DECISION NOTICE

Application Ref: R/138/20/PL

55 Milton Avenue
Rustington
BN16 2PL

Demolition of garage & construction of 1 No. 2-storey chalet dwelling (resubmission following R/182/18/PL).

**Proposed Floor Plans
and Roof Plan**

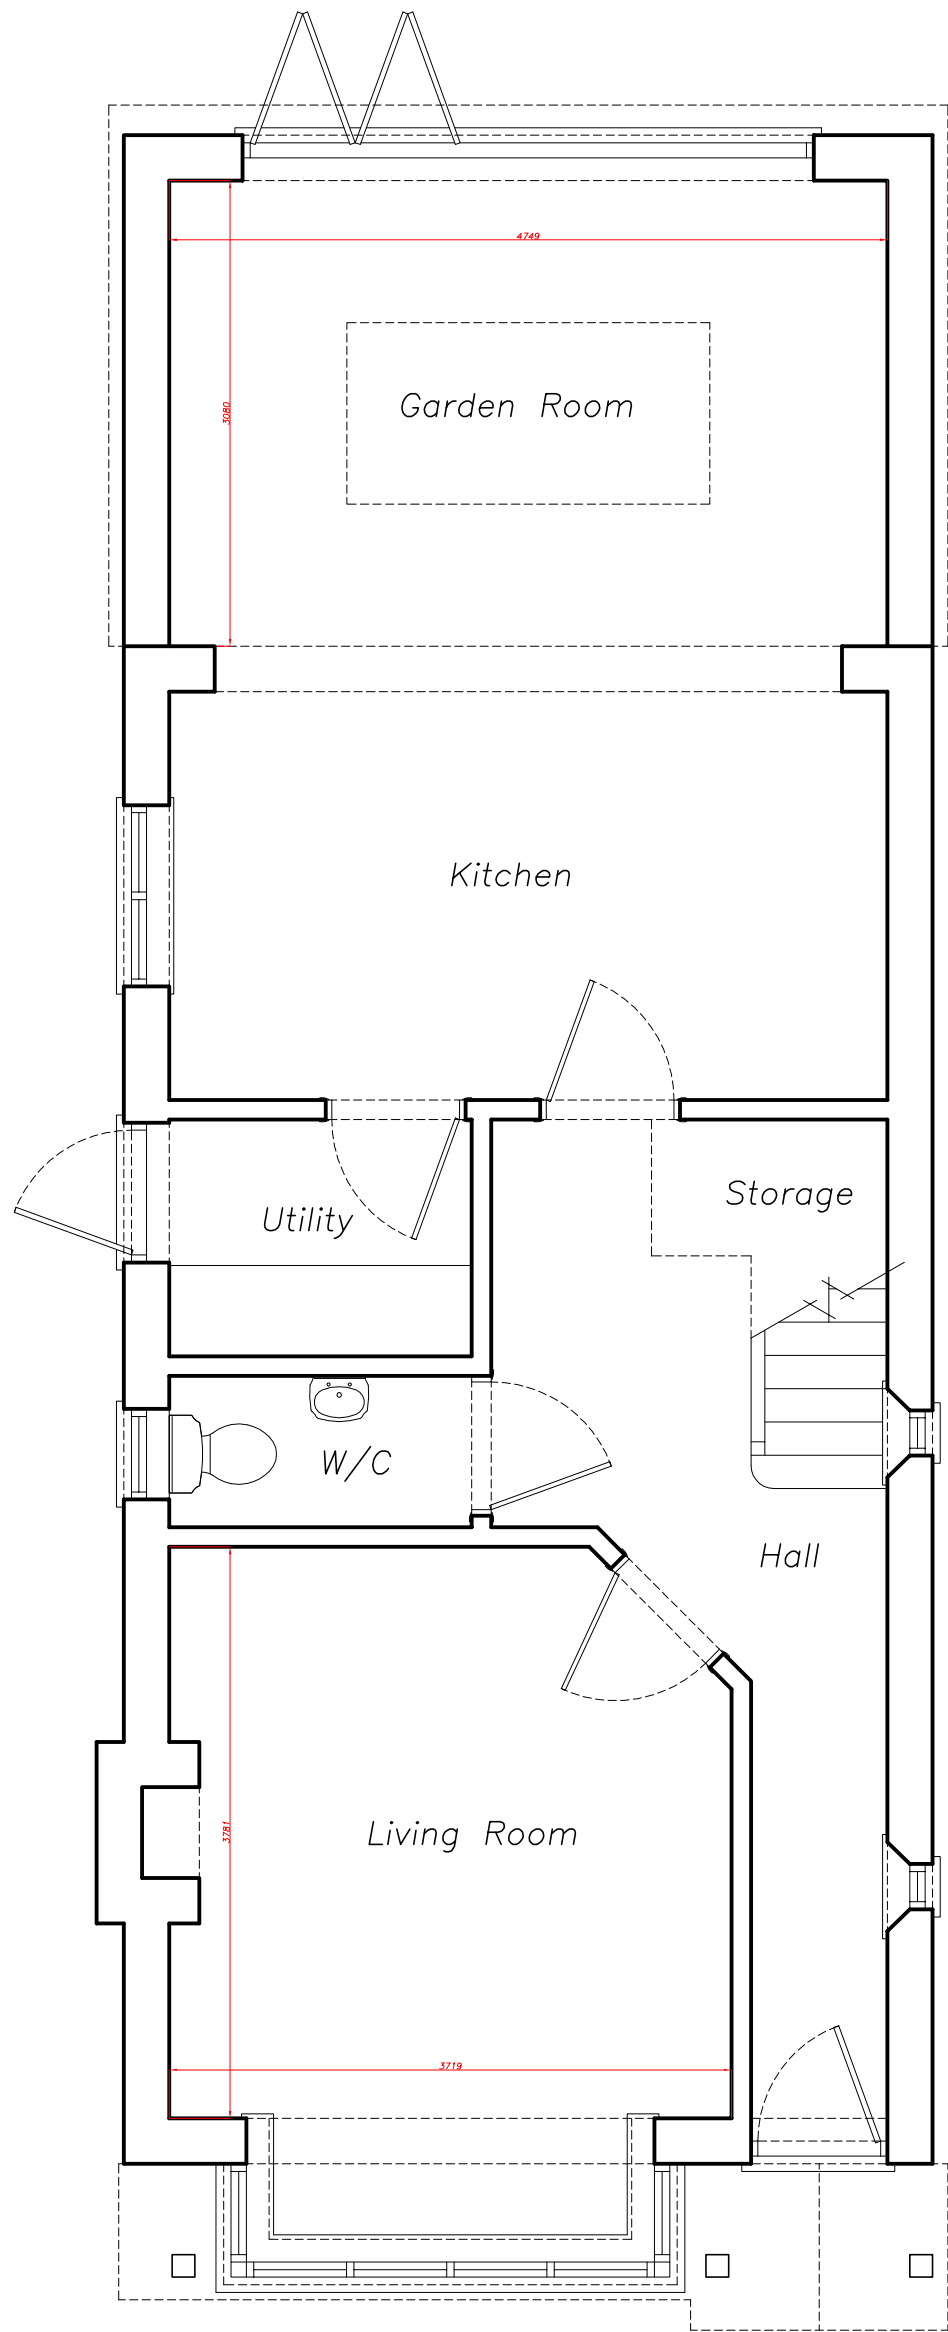
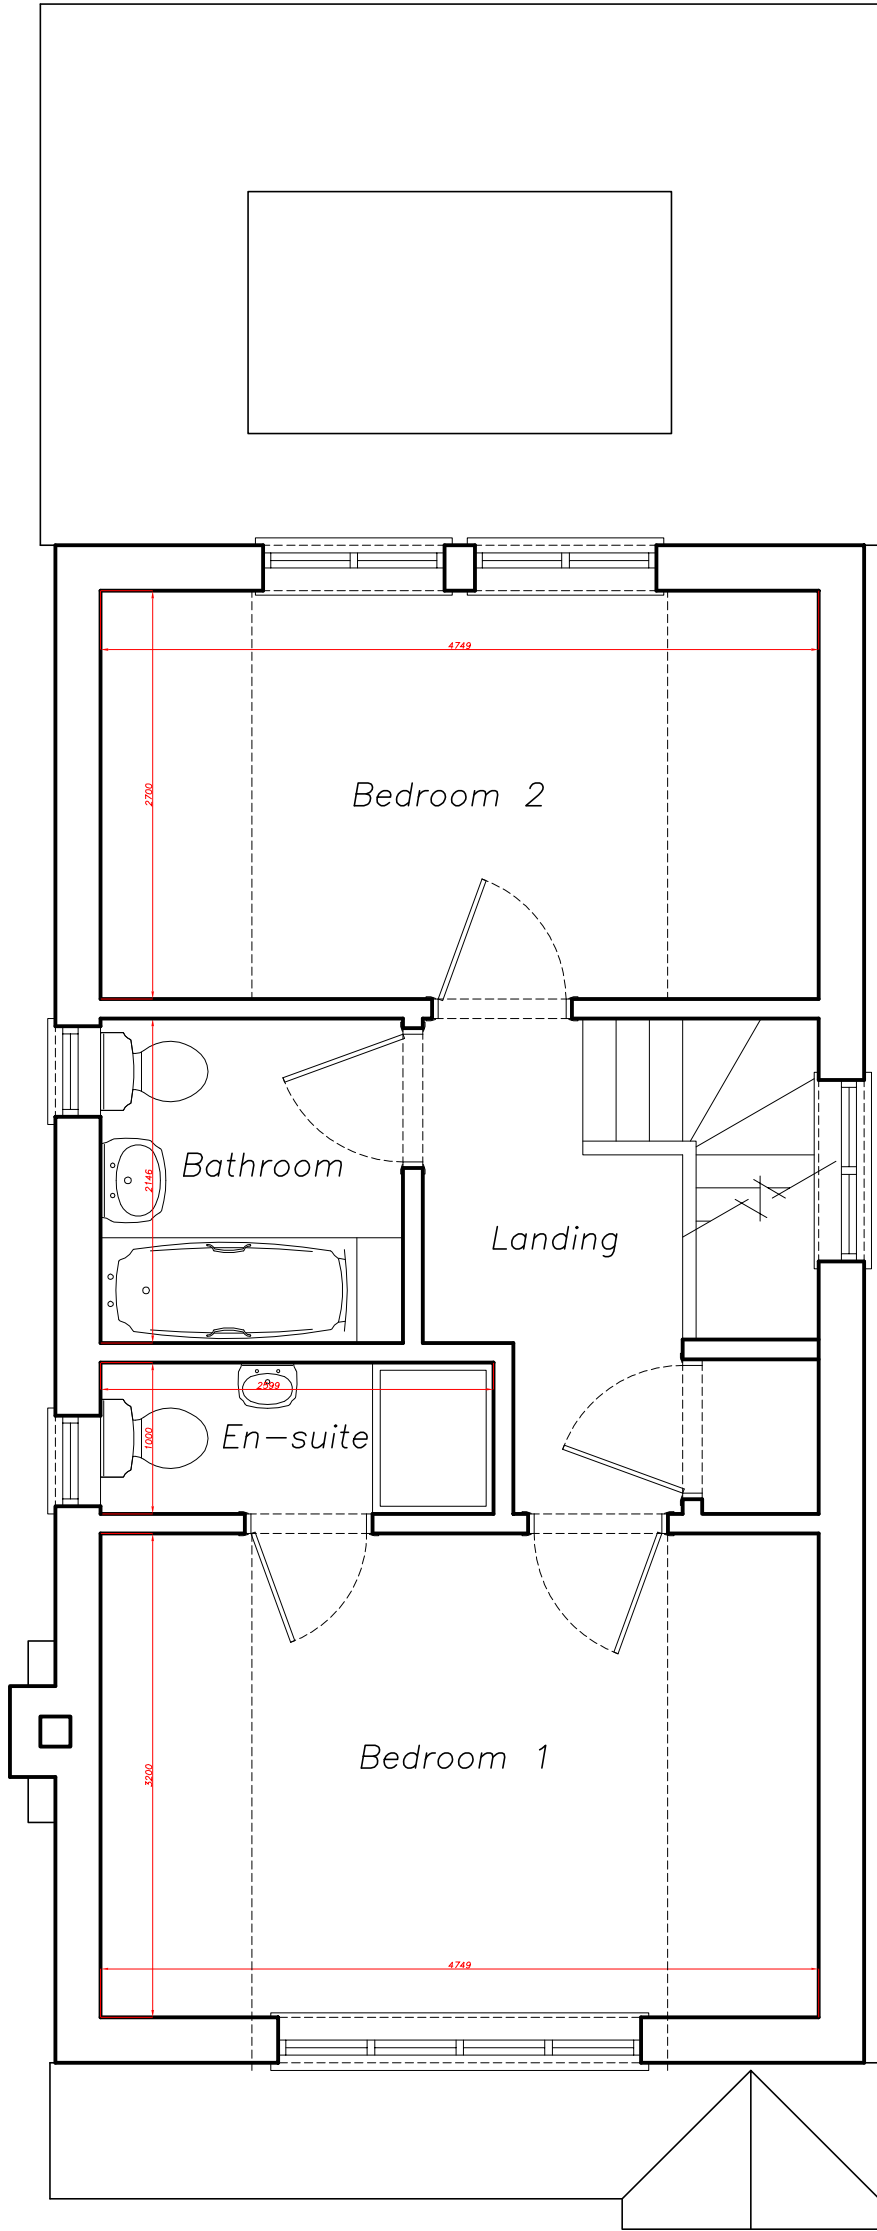
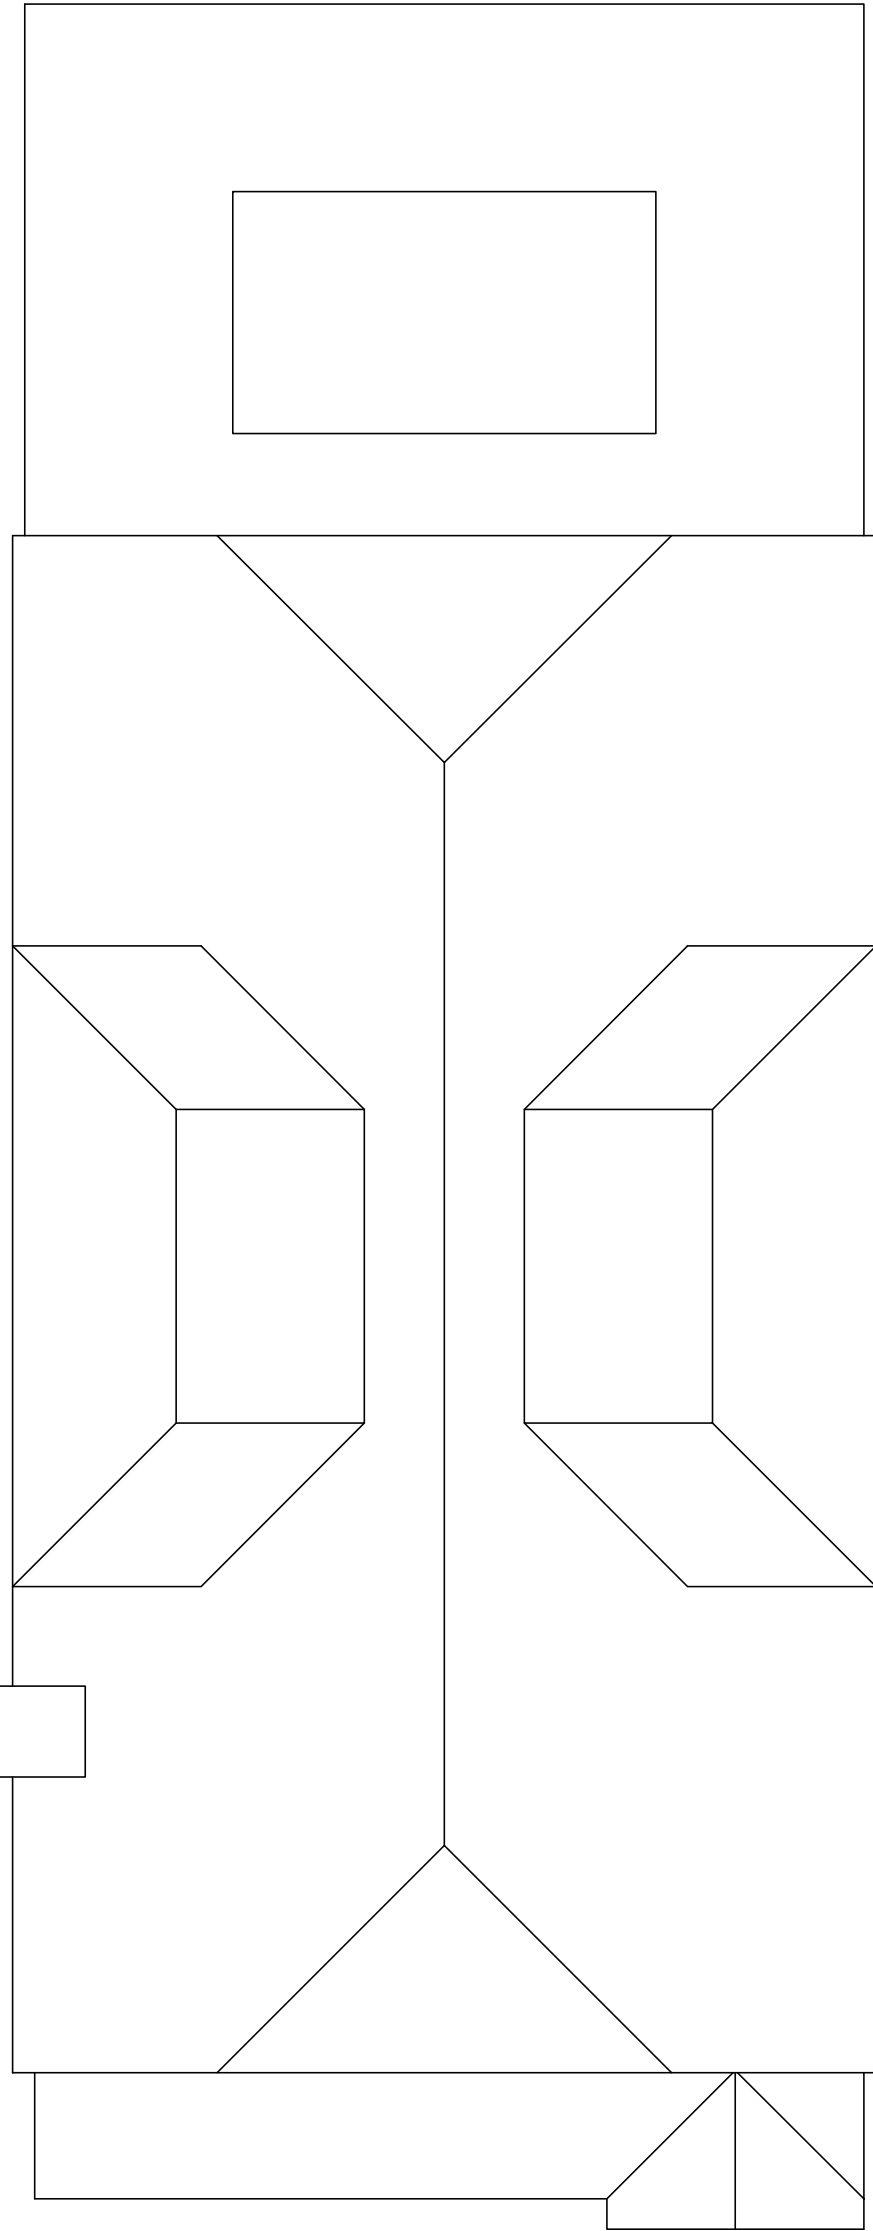
- 1 Given the size, shape and width of the site and the height, design and position of the dwelling the development would sit at odds with the street scene setting, damaging the character of the established residential area. The proposal would therefore result in an unduly cramped form of development contrary to policies D SP1 and D DM1 of the Arun Local Plan, & Policy 2 of the Rustington Neighbourhood Plan.
